**Development Review Board (DRB)  
Review Comments  
Utility Development Section  
Reviewer: Kristopher Cadena, P.E.  
Phone: 505.289.3301**

<b>DRB Case No:</b>  1000032	<b>Date:</b>  10/26/16	<b>Item No:</b>  #2
<b>Zone Atlas Page:</b>  G-11	<b>LOCATION: Lot X-1-A2 University of Albuquerque Urban Center</b>  <b>Coors NW between St. Josephs Dr. and Milne RD.</b>	
<b>Request For: 16DRB-70353 EPC Approved SDP for Subdivision</b>

DRB Project Number: 1000032  
Coors Pavilion

SUBJECT: EPC Approved Site Plan for Subdivision

A1 SITE PLAN
1" = 60'-0"
0 60' 120'

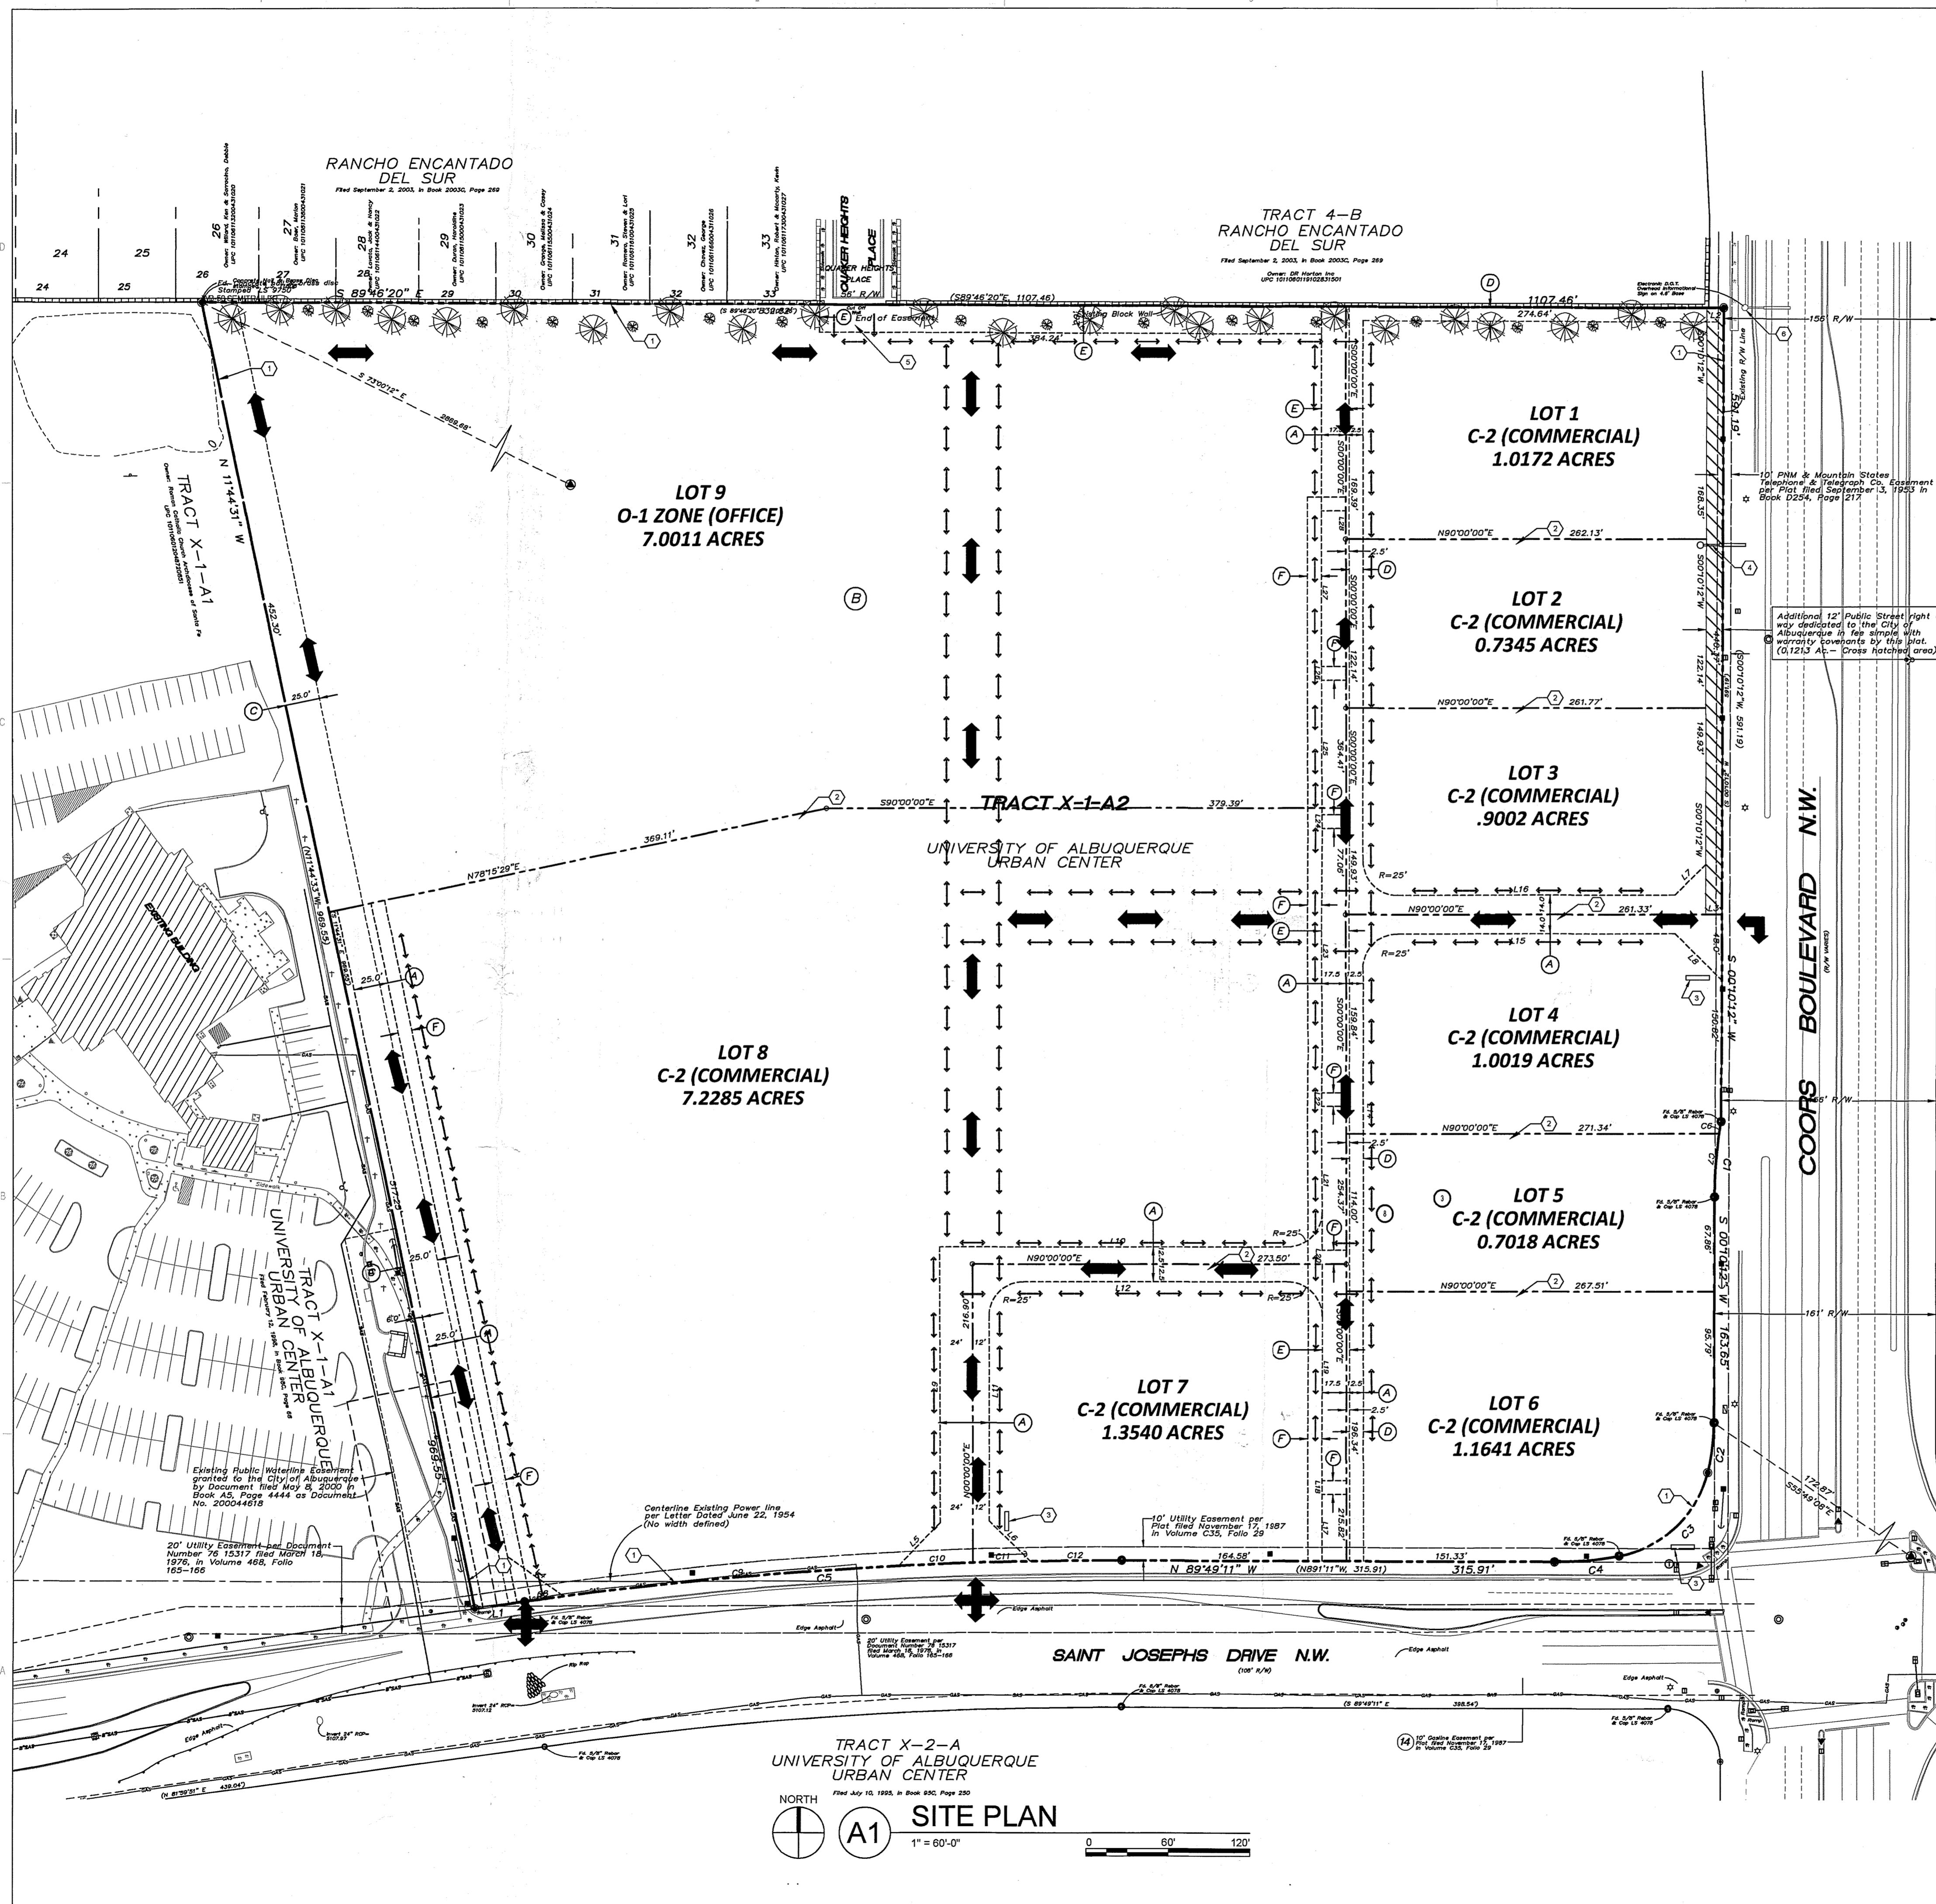
1. The Traffic Impact Study (TIS) needs to be approved prior to approval of the site plan. This includes approval of access on Coors from NMDOT.
2. Perform an overall quality control check. It appears some keyed notes are not pointing at the correct items.

Drawing file: 1000032 ReSub Oct 19 2016 / 10. 6010 SHEET 01 UTIL 101016.pdf

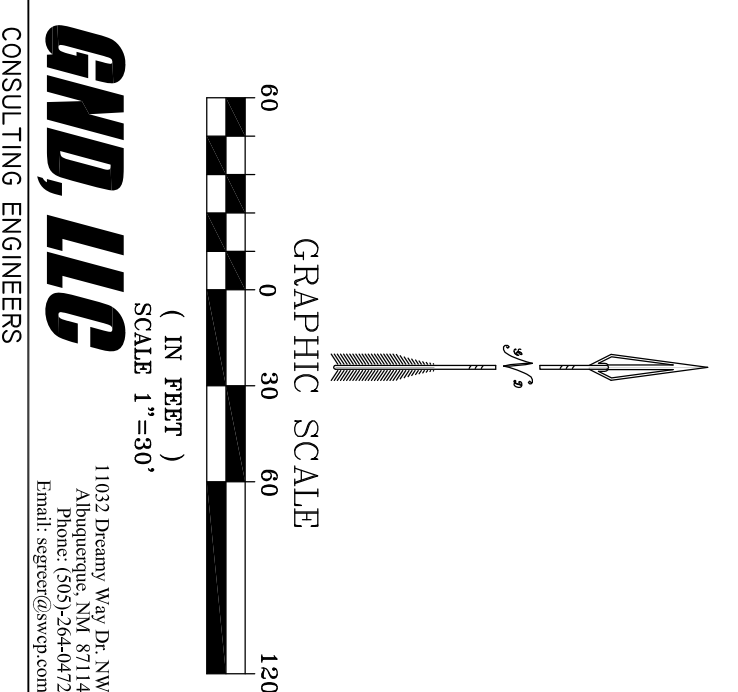
- c. Waterline service and fire protection will be determined in the availability statement.
    - i. There is an existing 16" concrete cylinder water transmission line along St. Joseph's Dr. with two 16" stubs located just west of Coors Blvd. A distribution

main extension may be required along the property frontage of St. Joseph's Dr. This waterline may qualify for prorating the property along the south Side of St. Joseph's Dr. This extension may be required on the infrastructure list and financially guaranteed. The availability statement will provide the official requirements for service.

- ii. There may be a need to provide for exclusive public waterline easements onsite to provide for a looped connection from the existing 8" waterline located north of the site along Quaker Heights Pl., to the existing 10" waterline stub located at the southwest corner of the subject property (existing Lot X1A1). This may be a requirement based on the required fire flow requirements. The availability statement will provide the official requirements for service.
- iii. Pending fire flow requirements, an onsite public waterline may not be required, so private easements for private water services and fire lines may be needed to provide service from existing public waterlines along Coors Blvd./St. Joseph's Dr./Atrisco Dr. The availability statement will provide the official requirements for service.
- iv. Onsite sanitary sewer shall be private.
- v. Provide a utility plan for review.
